Application no: **3/2021/0418**

Address: **1 Dorset Drive Clitheroe BB7 2BQ**

Proposal: **Proposed boundary treatments to dwelling. Resubmission of 3/2020/1049.**

The LHA have reviewed PD drawing number 1201-1-02 titled "Proposed Site Plan and Elevations" and understands that the site access will become a gated access following the proposal.

Plan

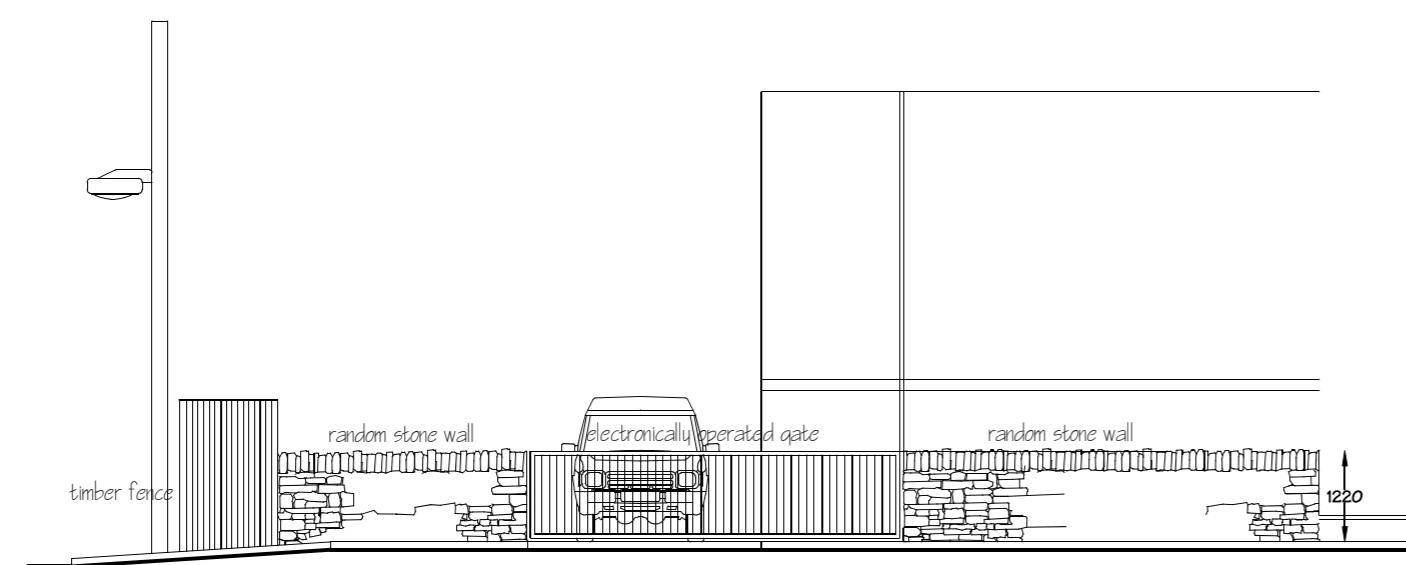
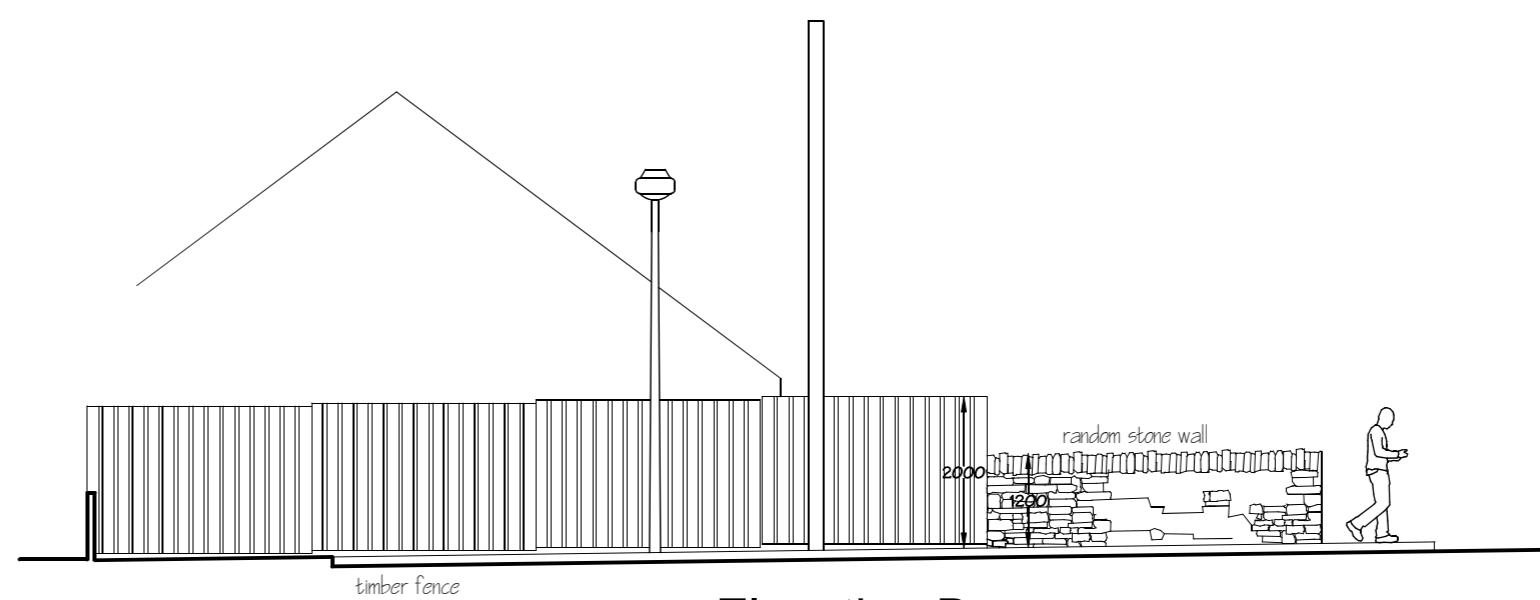
For the LHA to accept a gated access, the gate needs to be setback a distance of 5m from the edge of the footway. However, the LHA have reviewed the drawing and understands that the gate will be set back a distance of approximately 1.88m. Therefore, for the LHA to support the proposal, a revised drawing should be provided which shows the gate to be set back the minimum distance of 5m behind the footway.

The LHA also require the proposed boundary wall fronting the dwelling to be reduced from 1.22m to a height no greater than 1m, to aid visibility splays at the entrance of the driveway. These changes to the landscaping at the site should also be shown on the revised drawing.
